Application no: H14-0095-11

Description: Proposed extension forming garage, bedroom and en-suite

Amendment: Amended design (dwg. nos. JWM/MW/005A, 006A,
007A, 008A, 009A, 0010A and 011A)

Proposed extension to 15 Market Way-H14-0095-11

Project JWM/MW/006A	Sheet PROPOSED ELEVATION
Date 21/03/11	
Scale 1:50

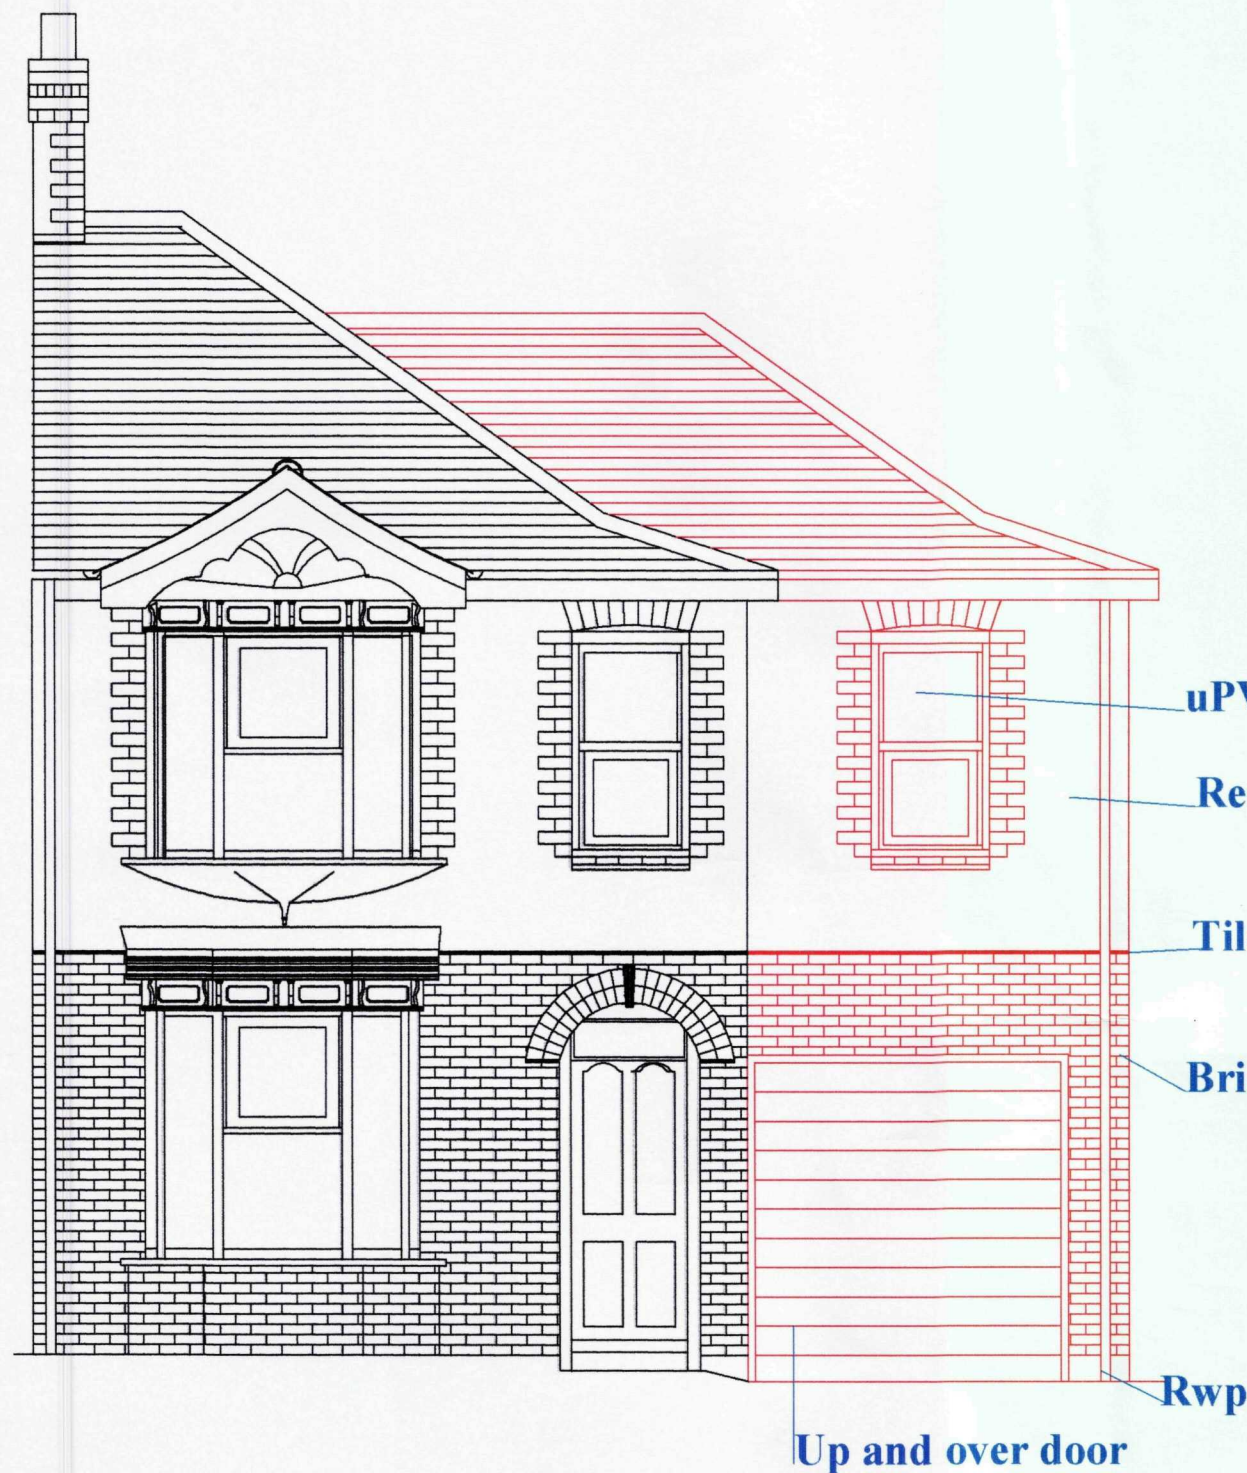
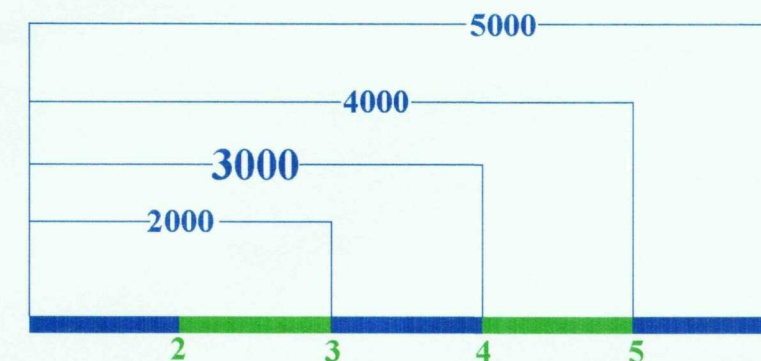
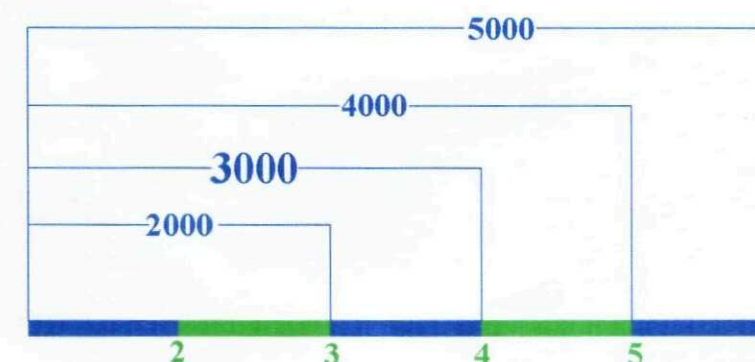
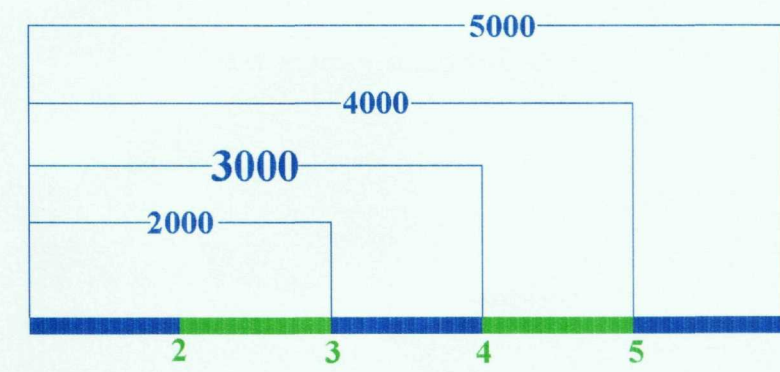
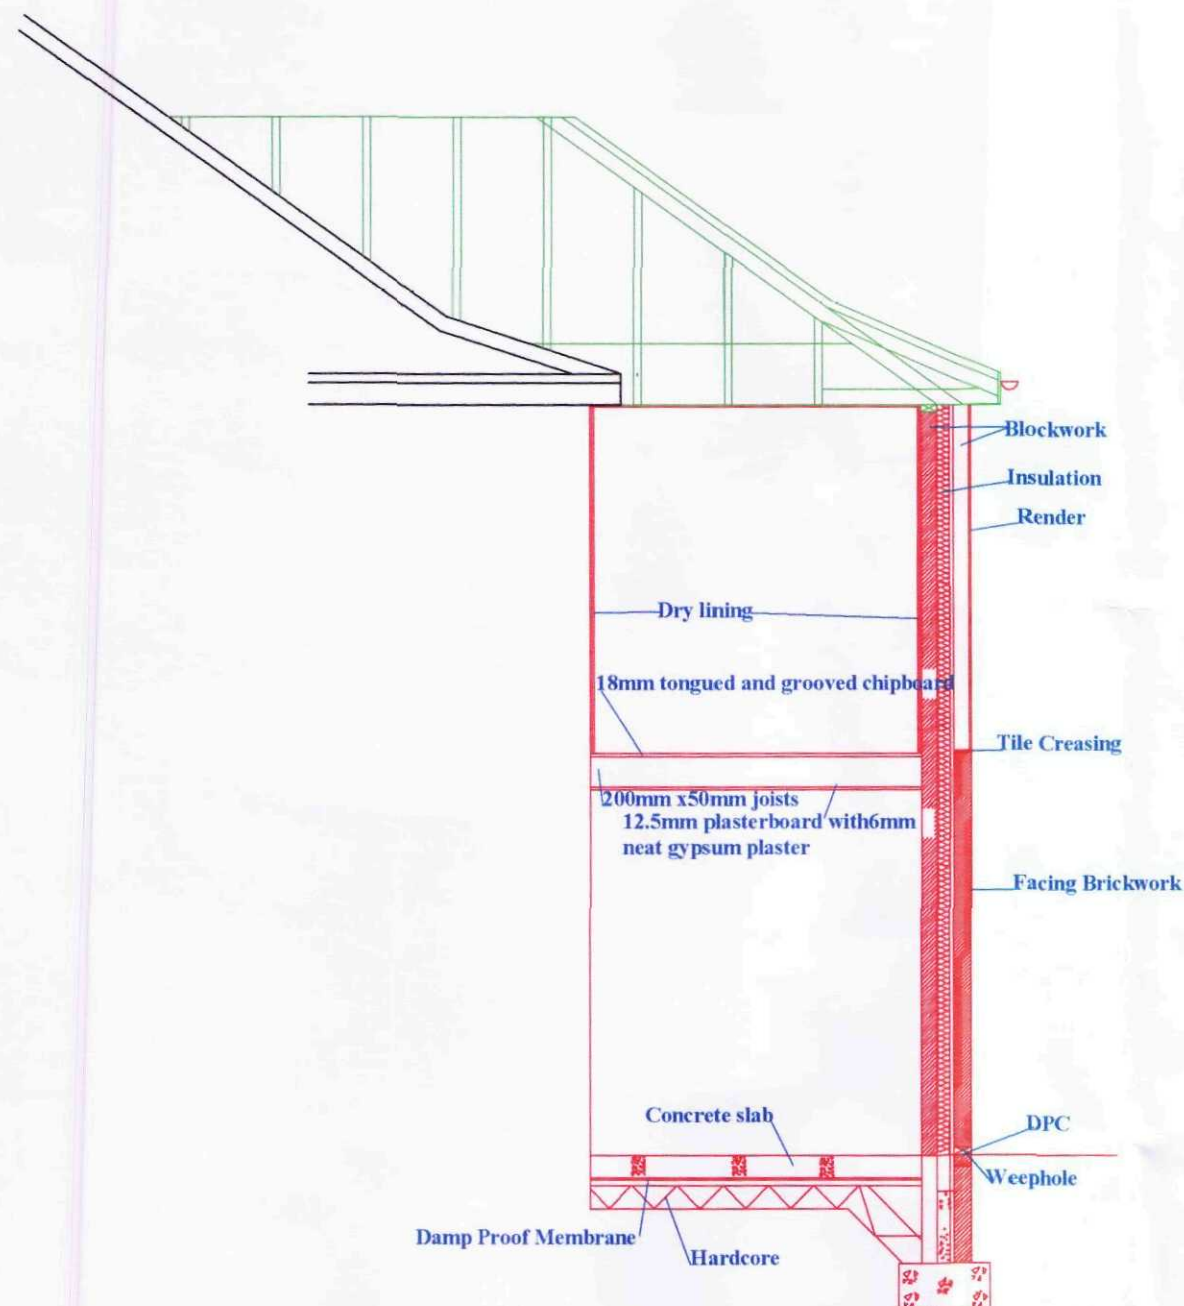
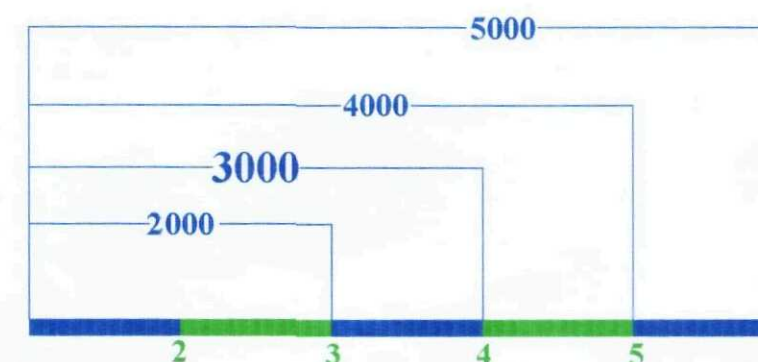
Further to our conversation regarding the roof to the above extension my client has decided to alter it to a pitched roof.

I therefore attach the revised drawings showing the alterations.
